Paddock House Spinney Lane Itchenor PO20 7DJ – Application for the variation of conditions 2 and 4 following grant of planning permission LA Ref: WI/22/02618/FUL

On behalf of our client, we submit a planning application in relation to the above site to vary conditions 2 and 4 attached to planning permission LPA Ref: WI/22/02618/FUL (granted on 17 January 2023) for alterations to the scheme for a replacement dwelling at Paddock House, Spinney Lane.

CLIENT **Ben & Emma Wilkin**
 PROJECT **Paddock House**
 DRAWING TITLE **Proposed Elevation Sheet 07**

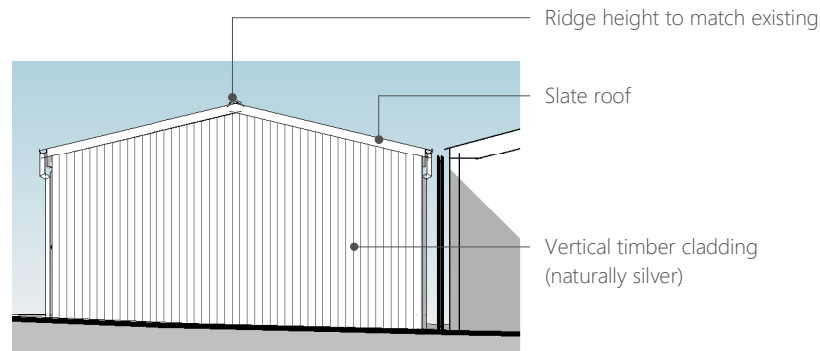
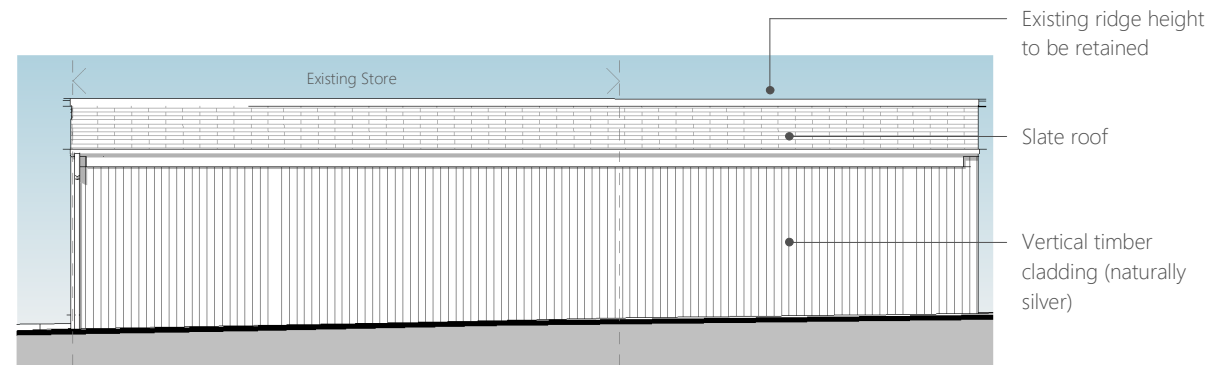
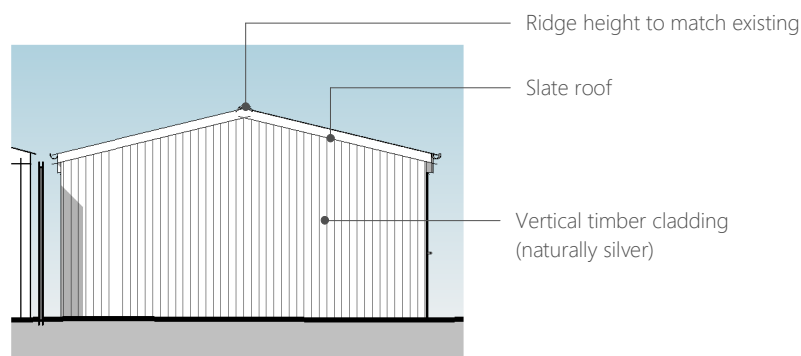
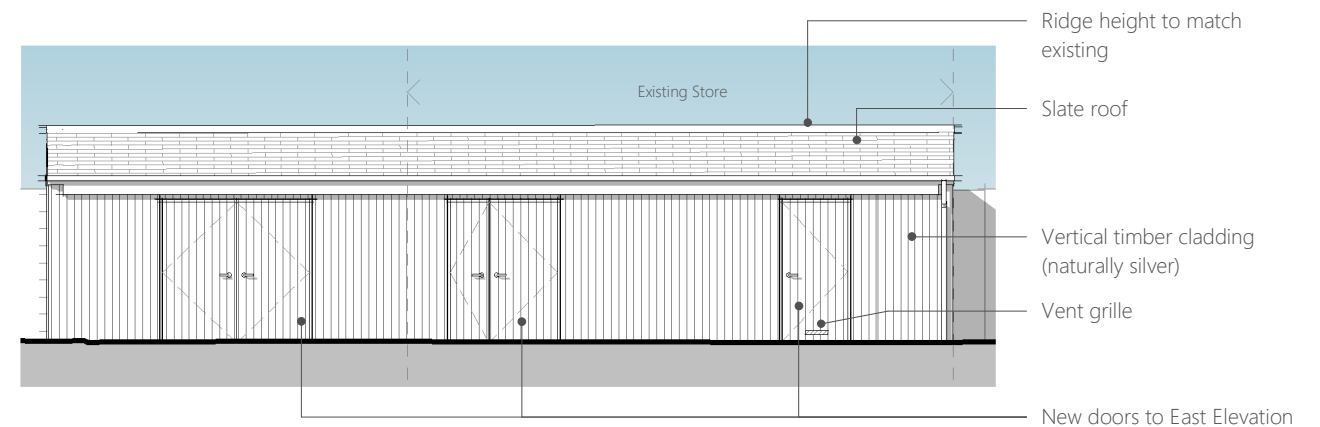
Following the grant of planning permission LA Ref: WI/22/02618/FUL the applicant/owners have been working with their architect on the working drawings and in going through the detailed design stages would like to make a change to the application to include a pergola to the consented summer house, as well as adding a garden store and A/C units.

Drawing: Tree Protection Plan

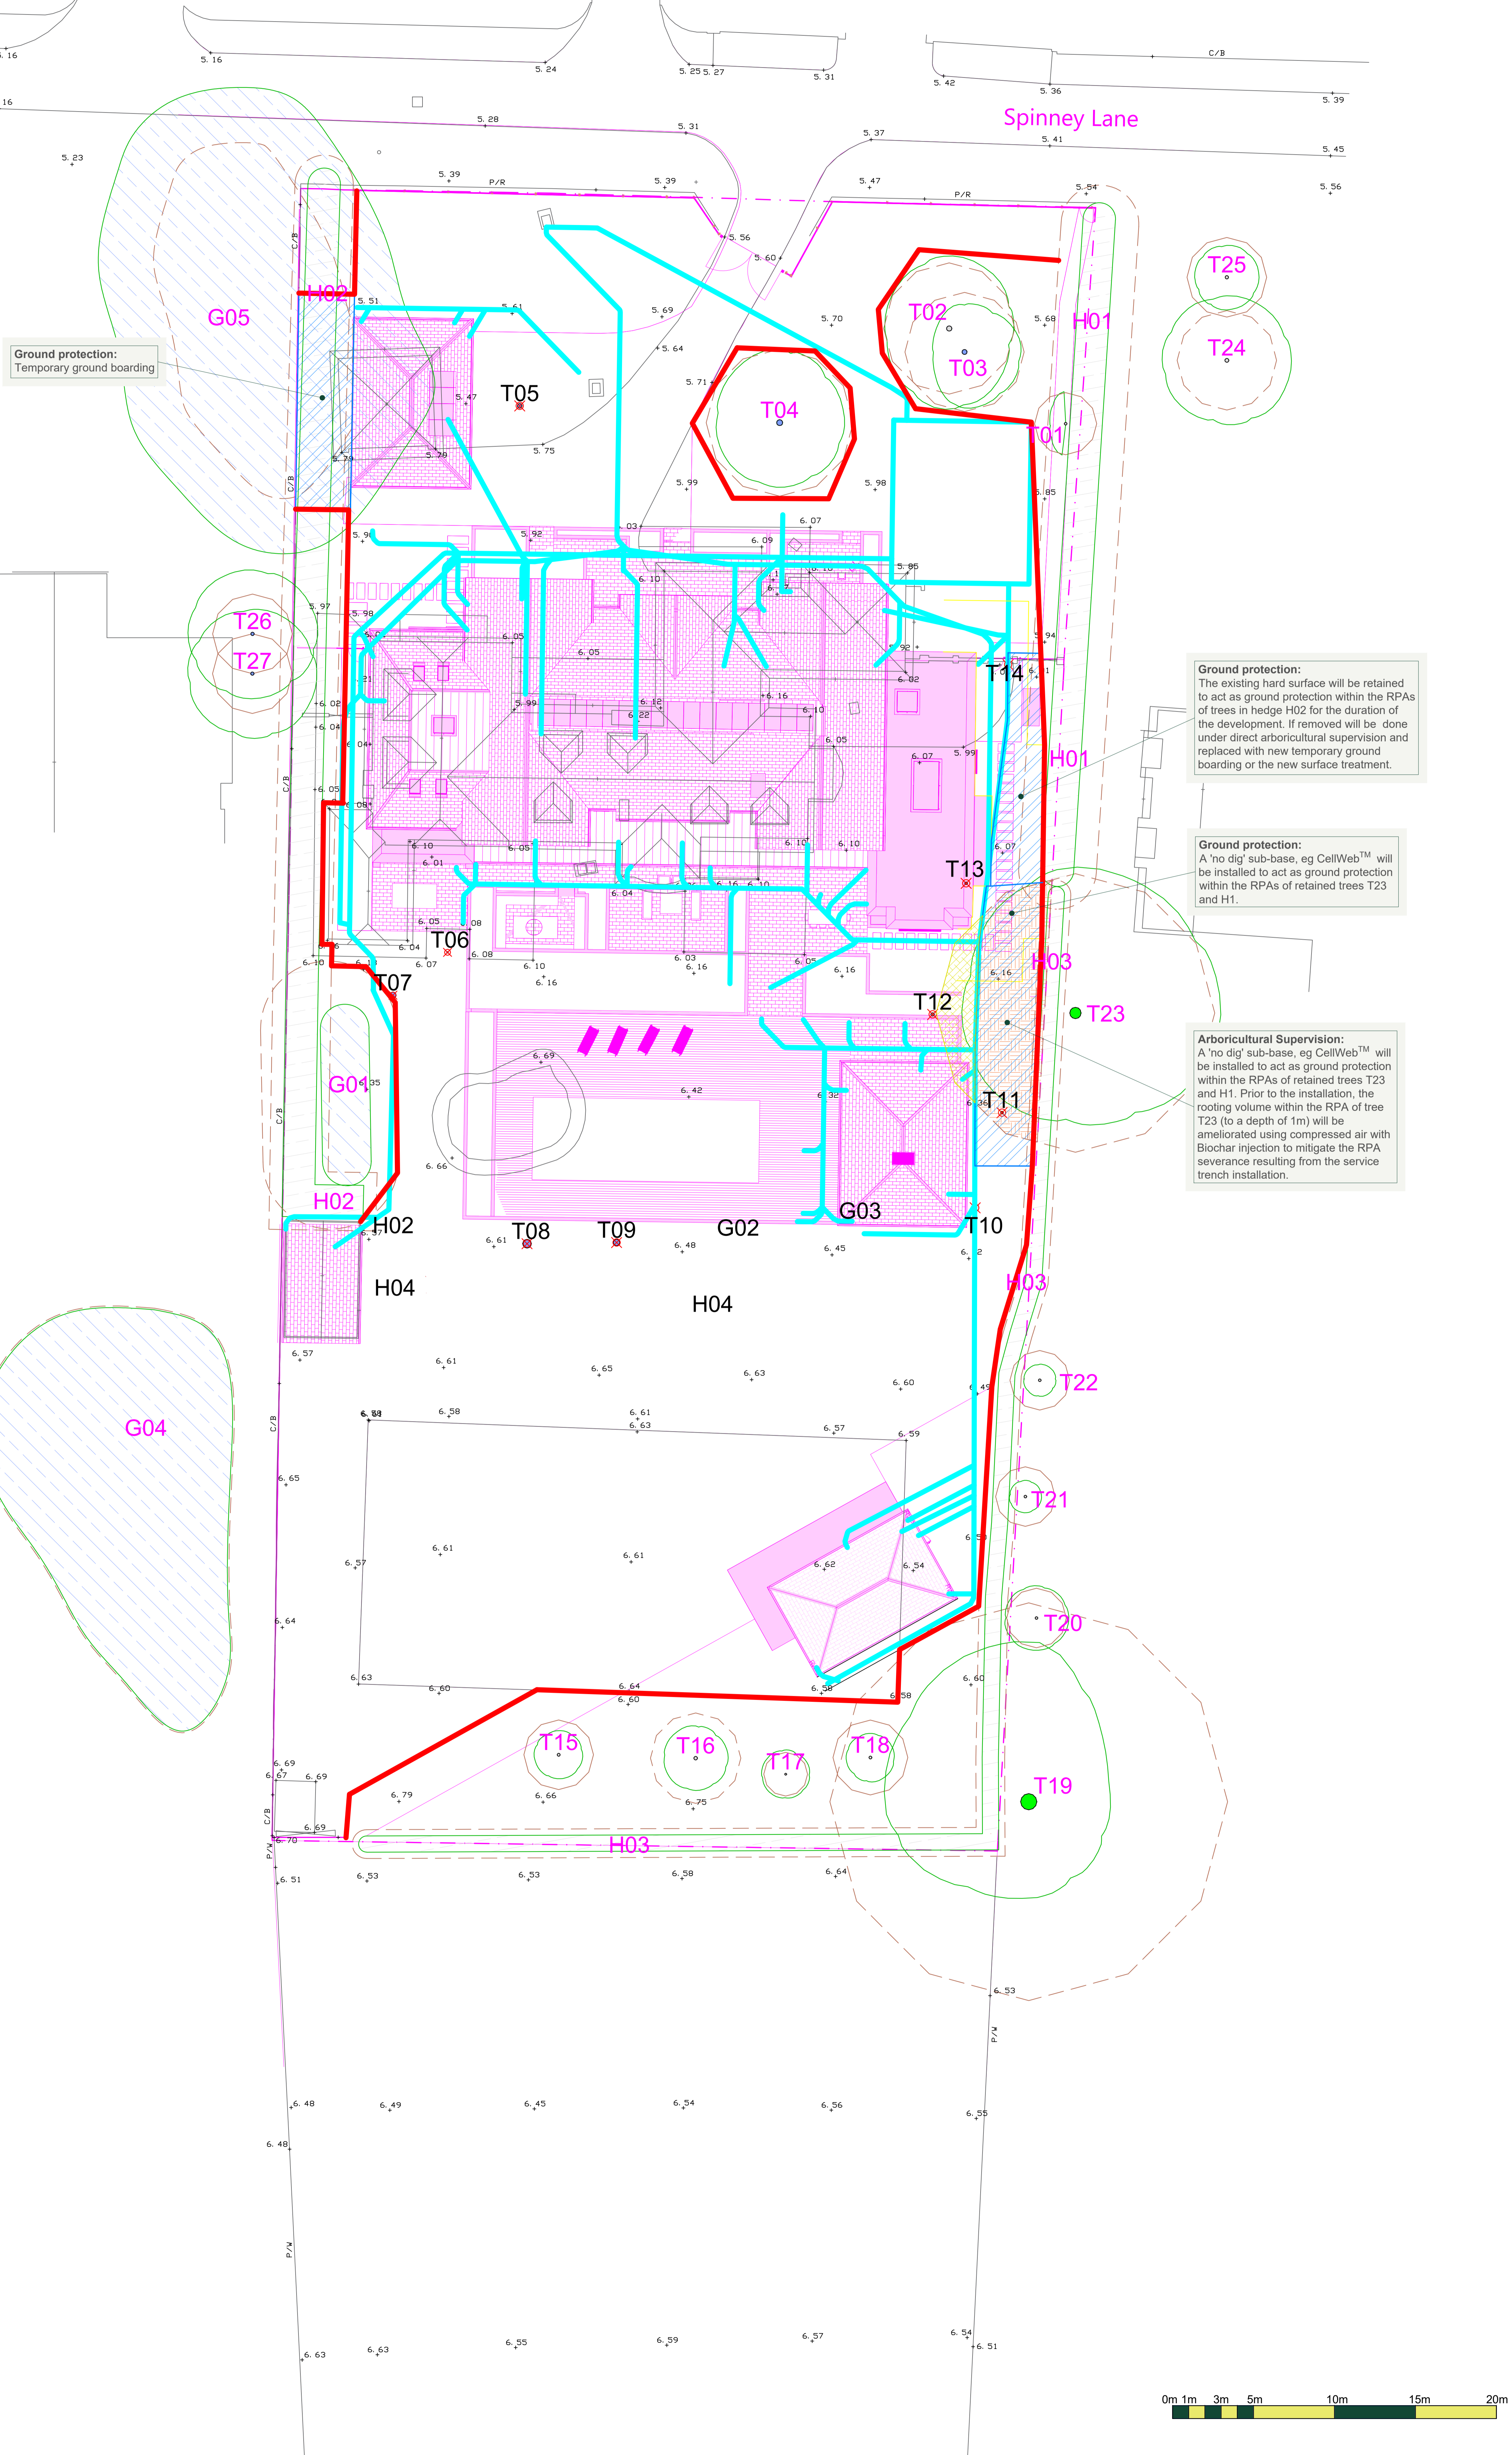
Further a tree shown retained on the approved Tree Protection Plan (T07) is now proposed for removal. The tree has been assessed by Arbtech as being in a poor state of health. Its removal is required to facilitate the changes to the proposal and would be replaced with additional tree planting.
